COMPLETED 07/03/06
DRB CASE ACTION LOG (PREL & FINAL)
REVISED 9/28/05

DRB Application No.: 06DRB-00901 (P&F) Project # 1004978
Project Name: LANDS OF CHARLES GRANDE
Agent: Jack's High Country Phone No.: 898-3707

- 12. Project # 1004978**
06DRB-00901 Minor-Prelim&Final Plat
Approval

PLAT OF TRACTS 2-A, 2-B AND 2-C LANDS OF CHARLES GRANDE

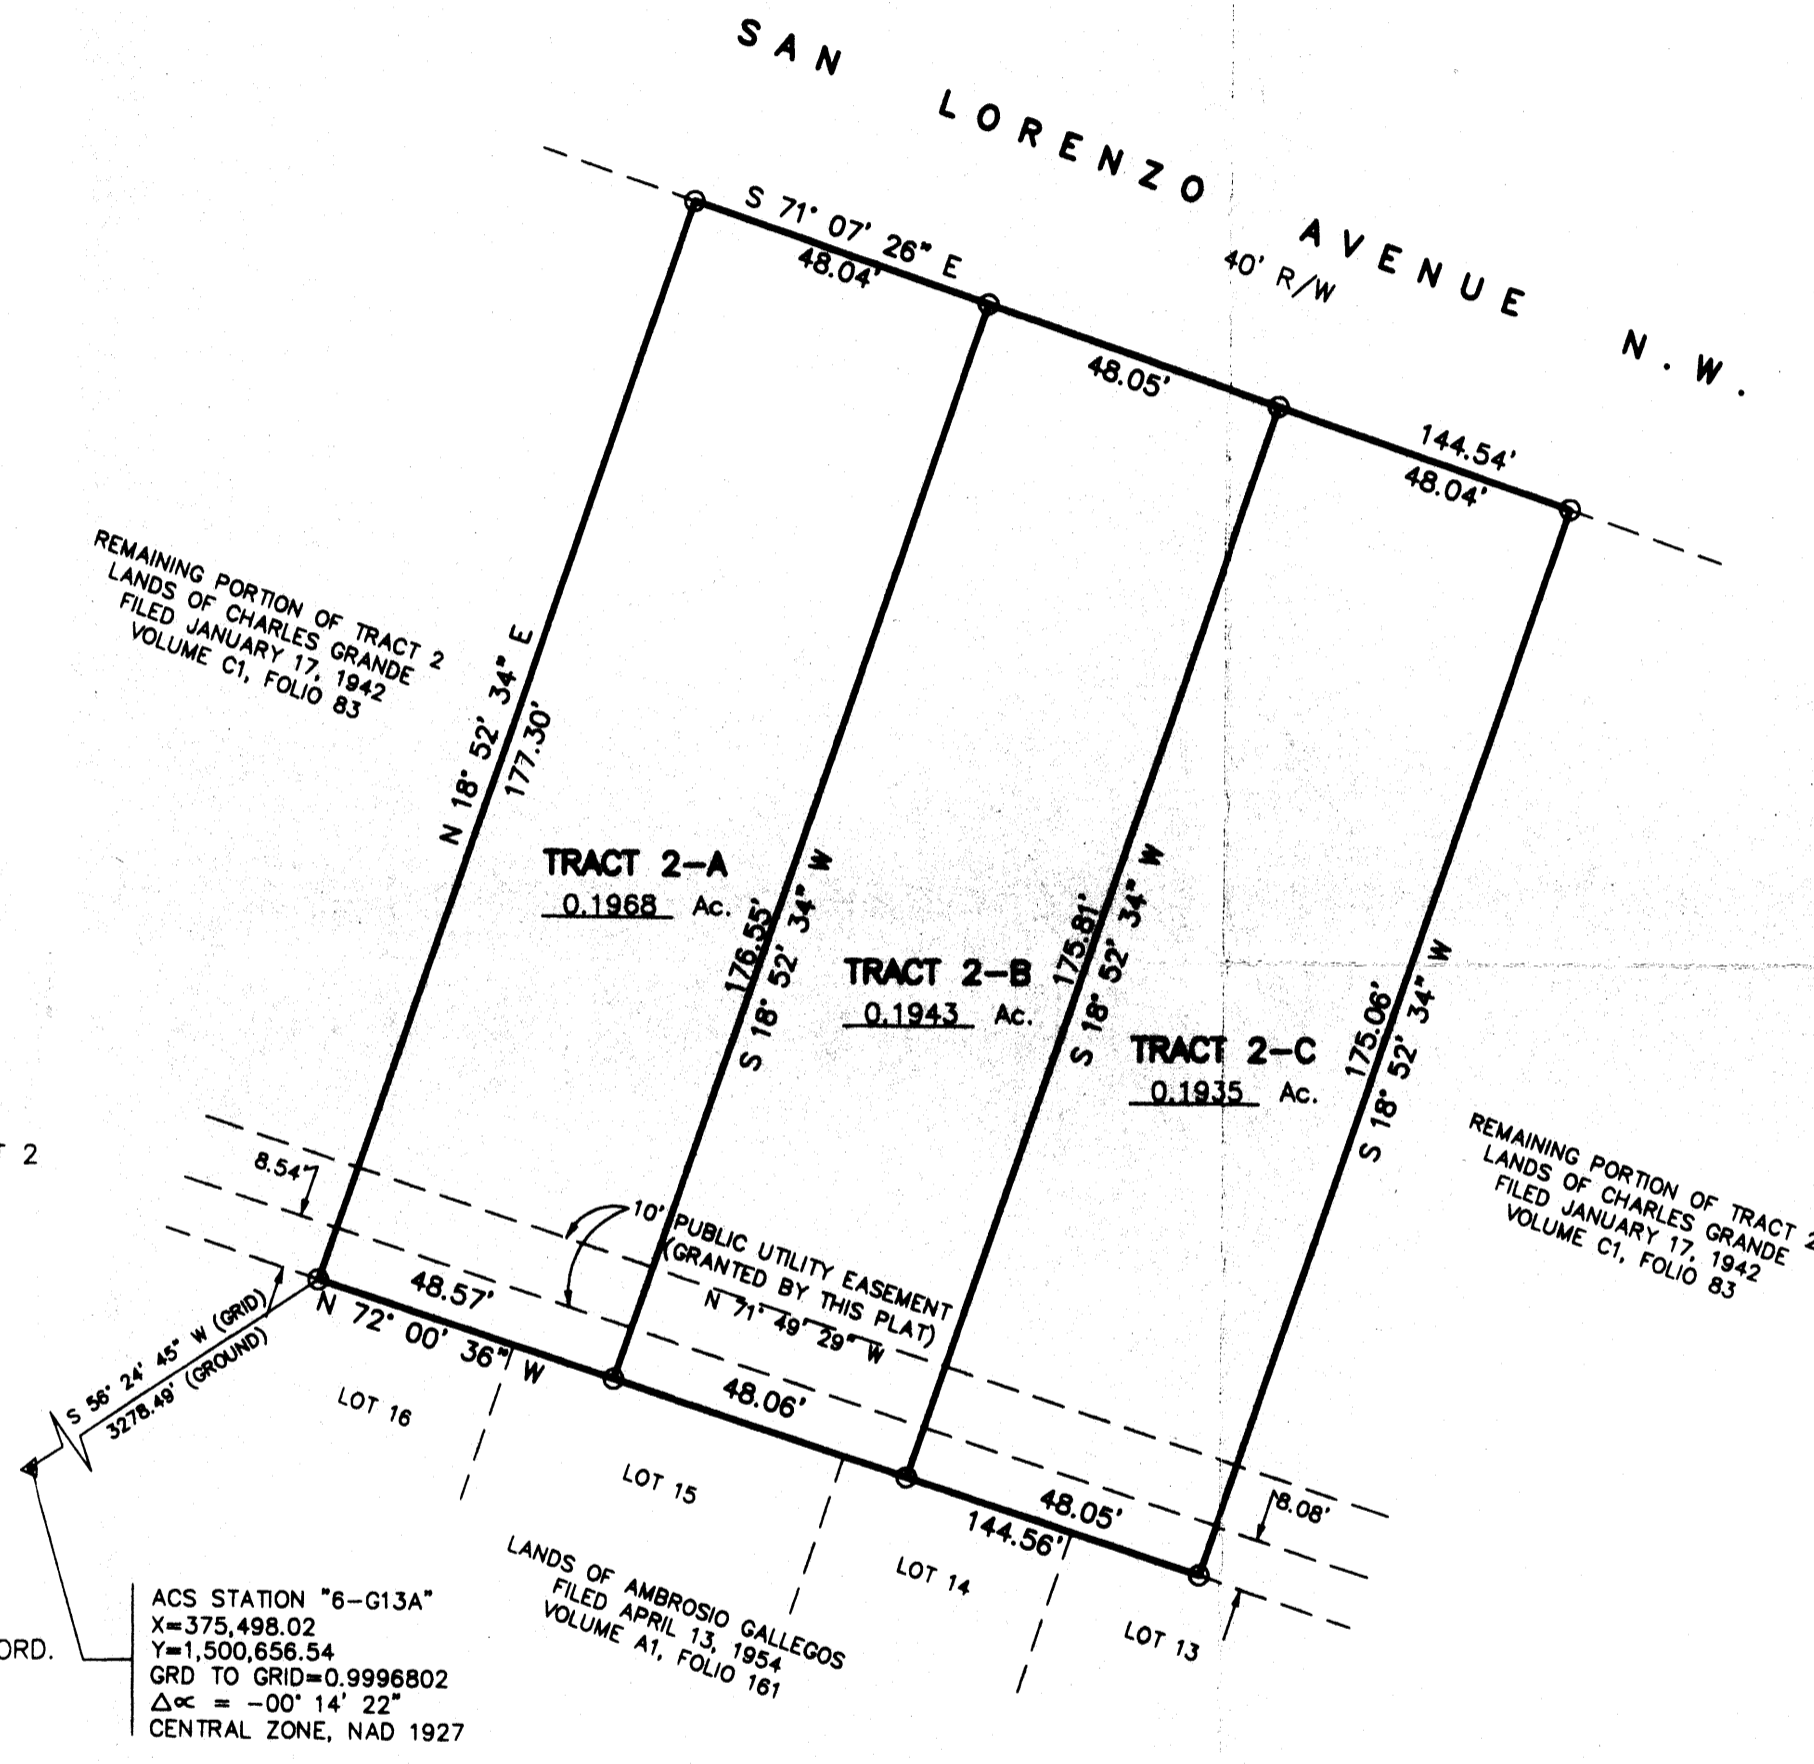
- TRANSPORTATION: row dedication along San Lorenzo Ave NW.
- _____
- _____
- _____
- _____
- UTILITIES: _____
- _____
- _____
- _____
- CITY ENGINEER / AMAFCA: _____
- _____
- _____
- _____
- PARKS / CIP: _____
- _____
- _____
- _____
- PLANNING (Last to sign): AGIS det
- Record the Plat
- _____
- _____

JACKS HIGH COUNTRY agent(s) for FRANK & KAREN CREAMER, ISMAEL CREAMER AND TONY & FELICA MALDONADO, request(s) the above action(s) for all or a portion of Tract(s) 2, **LANDS OF CHARLES GRANDE**, zoned R-1, located on SAN LORENZO NW, between GRANDE DR NW and the GRIEGOS LATERAL containing approximately 1 acre(s). [REF: ZA-84-243] (G-13) **PRELIMINARY AND FINAL PLAT WAS APPROVED WITH FINAL SIGN OFF DELEGATED TO TRANSPORTATION DEVELOPMENT FOR RIGHT-OF-**

**WAY DEDICATION ALONG LORENZO AVE NW AND
PLANNING FOR AGIS DXF FILE AND TO RECORD THE
PLAT.**
